February 24, 2022

Re: N-Demand Expansion
3801 Academy Parkway South NE
Traffic Circulation Layout
Engineer's Stamp 2-14-2022 (E17-D001J)

Based upon the information provided in your submittal received 01-03-2022, the above referenced plan cannot be approved for Building Permit until the following comments are addressed:

TRAFFIC
CIRCULATION
PLAN

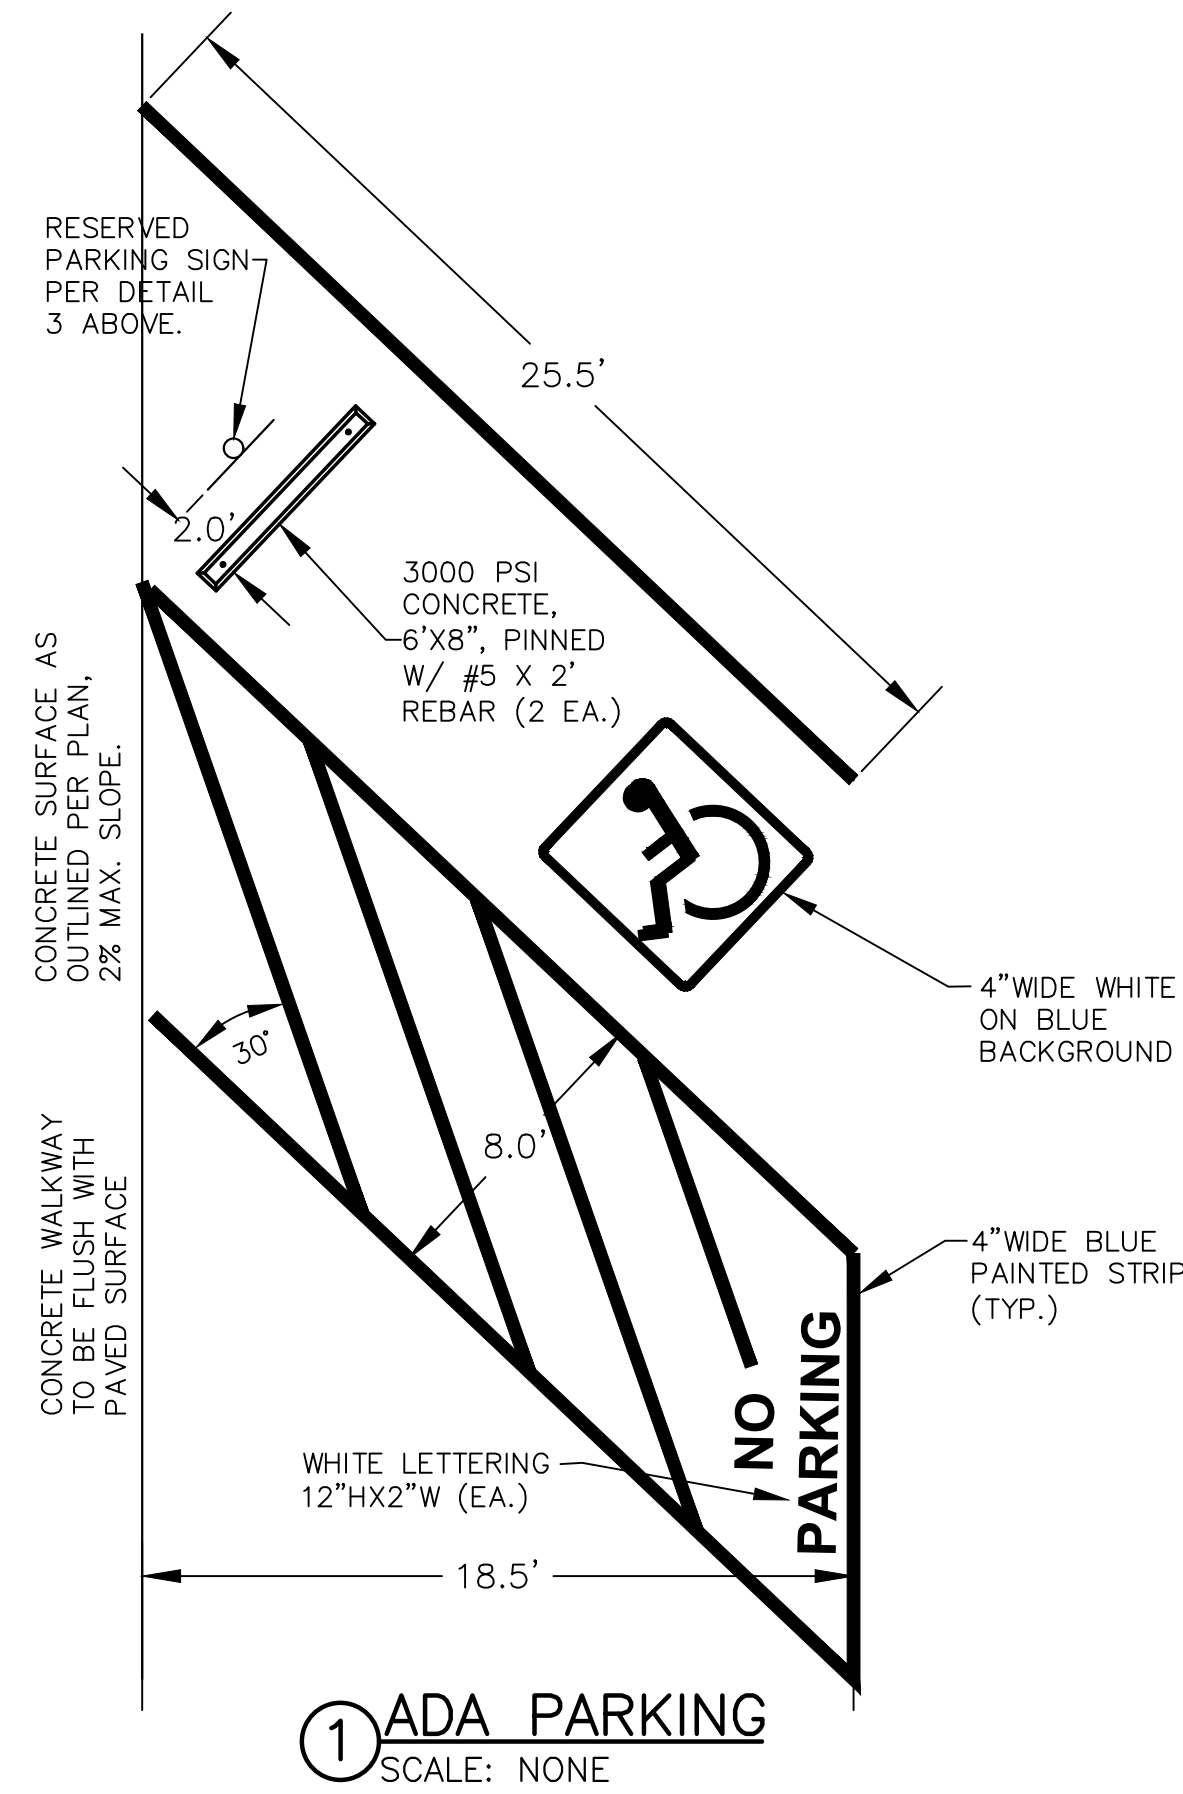
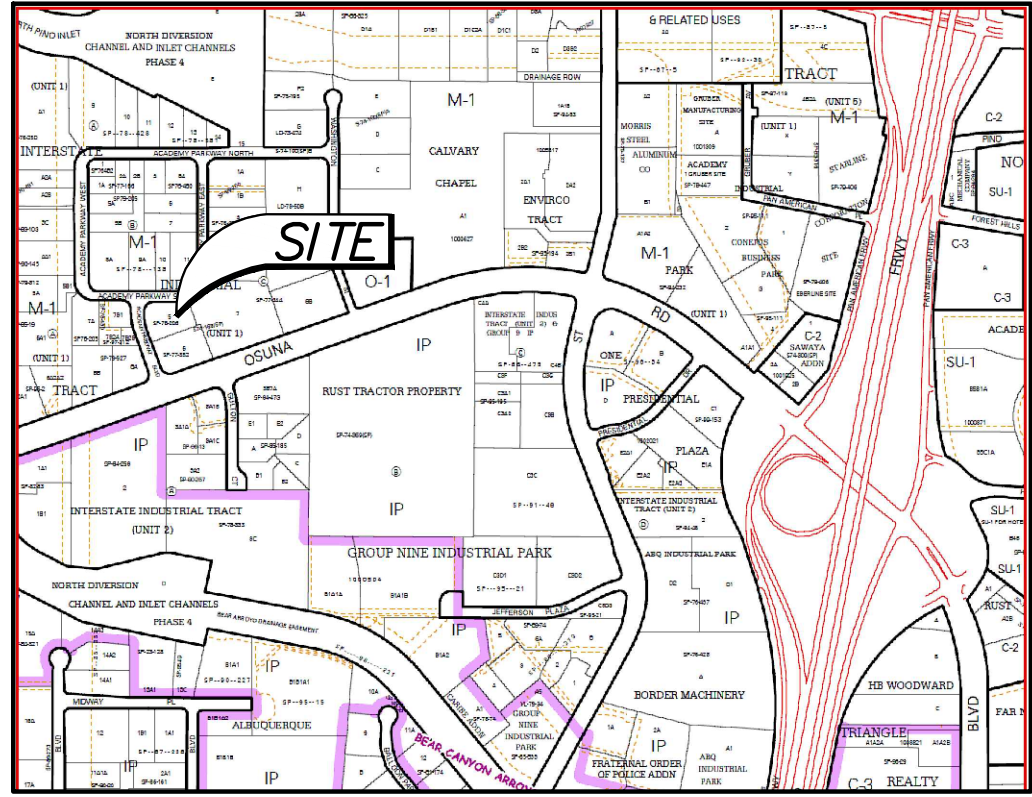
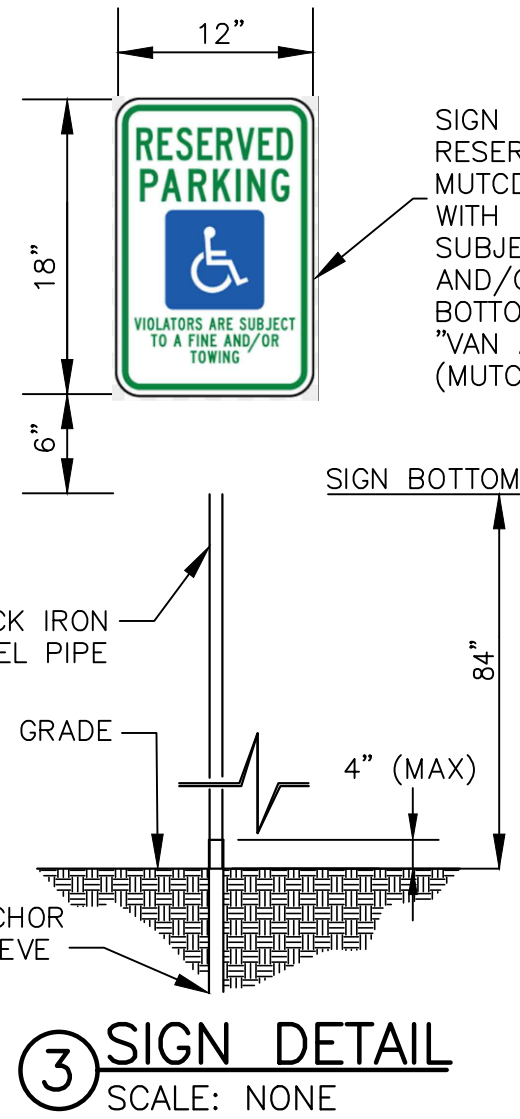
1. Listed all the number of Motorcycle parking spaces and Bicycle Racks required by the IDO.
2. Angle parking: drive aisle width should be 22 ft. Suggestion: change the angle of the parking stall to 60 degree. See the table below

4. Provide on-site ADA ramp's details.
5. South-west Entrance: Provide signs indicates that this entrance for employees only. Show the location of the sign on site plan.
6. Provide a copy of Fire Marshal Approval.
7. Provide a copy of Sidewalk Variance.
8. Please show clear site triangle at the North side existing drivepad. and add the following note to the plan: "Landscaping and signage will not interfere with clear sight requirements. Therefore, signs, walls, trees, and shrubbery between 3 and 8 feet tall (as measured from the gutter pan) will not be acceptable in the clear sight triangle.
9. Please specify the City Standard Drawing Number when applicable.
10. Please provide a letter of response for all comments given.
